**WELWYN HATFIELD COUNCIL – DEVELOPMENT CONTROL**  
**DELEGATED REPORT**

| <b>APPLICATION No:</b> | <b>S6/2008/322/FP</b> |

This application seeks full planning permission for the erection of a two storey rear extension and loft conversion including five dormer windows.

REVISIONS.			CONTRACT.	DETAIL.
NO.	DETAILS.	DATE		
			Extension at 45 Northaw Road East, Cuffley, Herts	Plans as Proposed
			CLIENT.	
			DRAWN. rgl	DRAWING NO. mp.245 A
			REVISOR	
			STATUS.	
			DATE. july 03	
			SCALE. 1:100

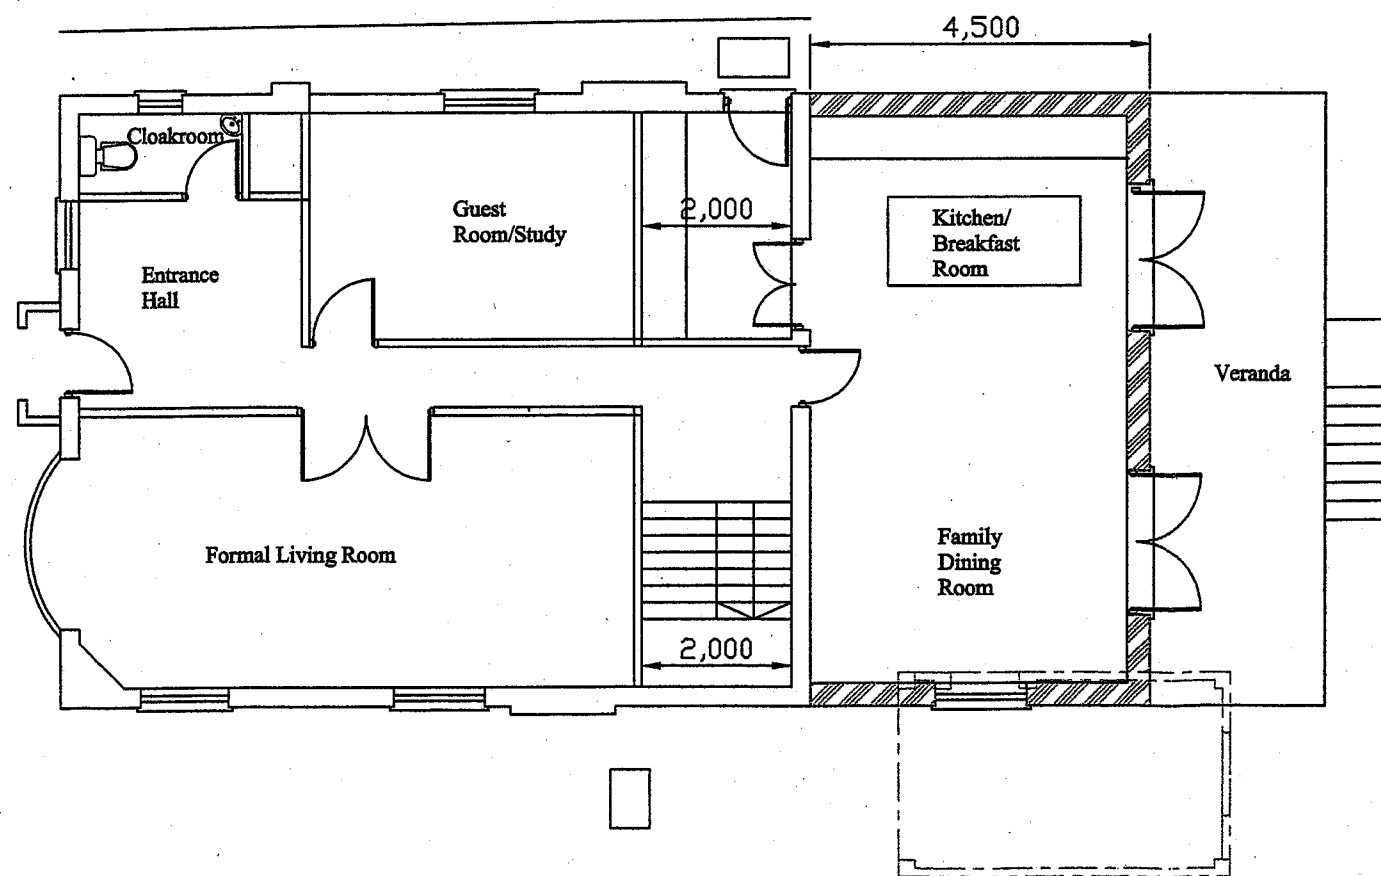
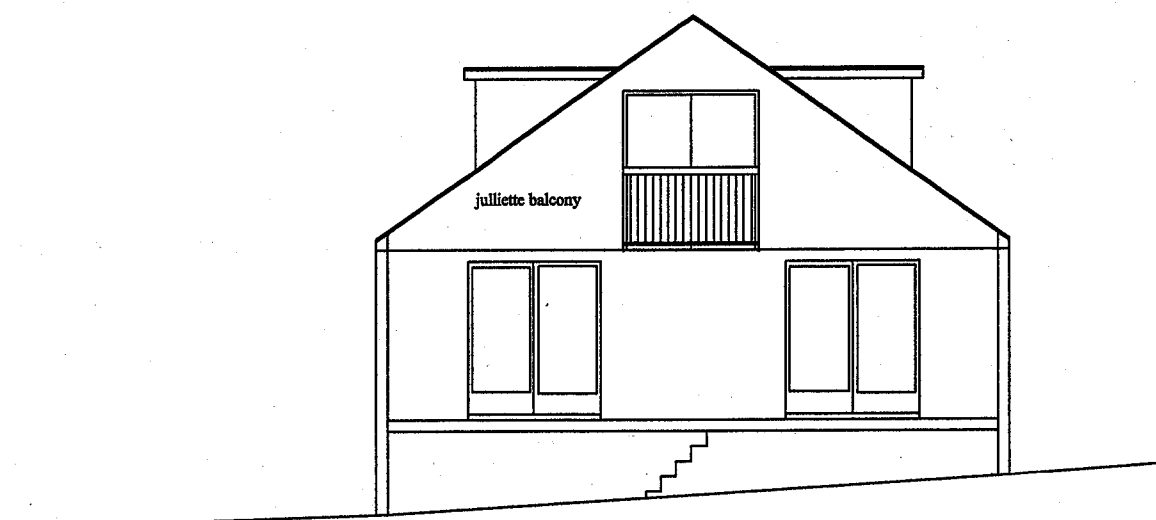
The proposed rear extension would measure of 4.5m in depth x 8m in width across the entire rear elevation. One dormer window is proposed in the front elevation, two in the north side elevation and two in south side elevation. The proposed extension and loft conversion retain the existing ridge height and the side dormers would be finished with flat roofs set approximately 0.5m below the ridge to reduce their height and bulk. First floor accommodation would provide for three additional bedrooms and a bathroom. The rear elevation would feature two double patio doors at ground floor and a Juliet balcony at first floor. It is also proposed to construct a raised platform across the rear elevation extending approximately 2.2m in depth. Materials would match those of the existing building including tiles and render.

Planning application S6/2007/1545/FP granted permission for the erection of a two storey rear extension and a loft conversion including a dormer window to the front elevation. The current proposals retain the previously approved front dormer in addition to two side dormer on both the north and south elevations. The two storey rear extension would increase form 2.5m in depth to 4m.

REVISIONS			CONTRACT.	DETAIL.
NO.	DETAILS.	DATE.		
			Extension at 45 Northaw Road East, Cuffley, Herts	Elevations as Proposed
			CLIENT.	
			DRAWN. rgl	DATE. July 03
			REVISION.	SCALE. 1:100
			STATUS.	DRAWING NO.
				mp.26325 A

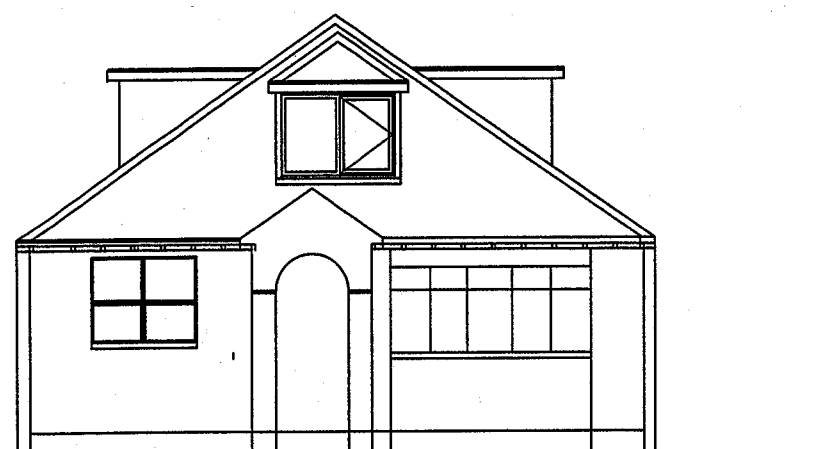
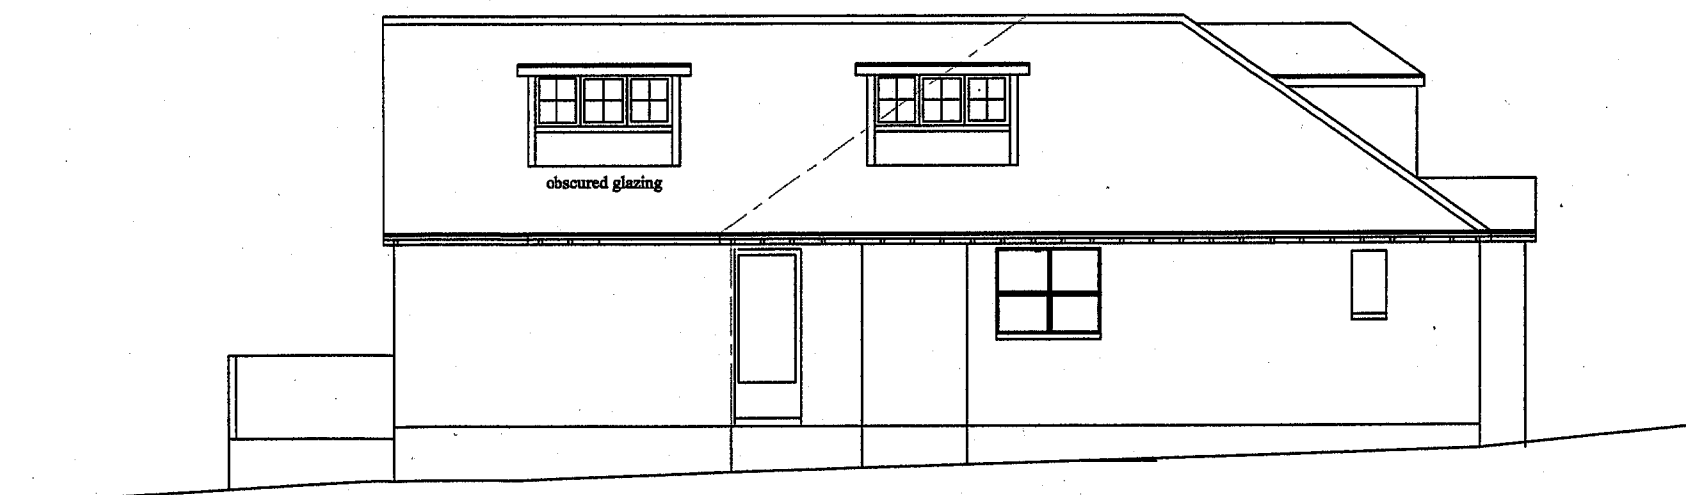
The two south facing side dormers would be fixed and obscure glazed by way of planning condition in order to prevent overlooking to an existing dormer and rooflight window at No.47 Northaw Road East. The two dormers in the north elevation would not result in any loss of privacy to No.43 Northaw Road East. The Juliette balcony in the rear elevation would have views to the rear garden and would not create any additional overlooking than that created from a window. In relation to the proposed raised platform, this would be similar in height and depth to the existing platform at No.43 Northaw Road West. Views from the raised platform would potentially overlook the adjoining rear gardens, however, the degree of overlooking would be no greater than existing and therefore would not result in a detrimental impact on private amenity.

1. C.2.1 – Time Limit
2. C.13.1 – The development/works shall not be started and completed other than in accordance with the approved plans and details mp.25 & mp.246 & mma.477 & Site Location Plan scale 1:1250 received and dated 19 Feb 2008 and mp.245A & mp.26325A received and dated 10 April 2008
3. C.5.2 – Matching Materials
4. C.7.9 – Fixed and Obscure Glazing (south facing dormer windows)
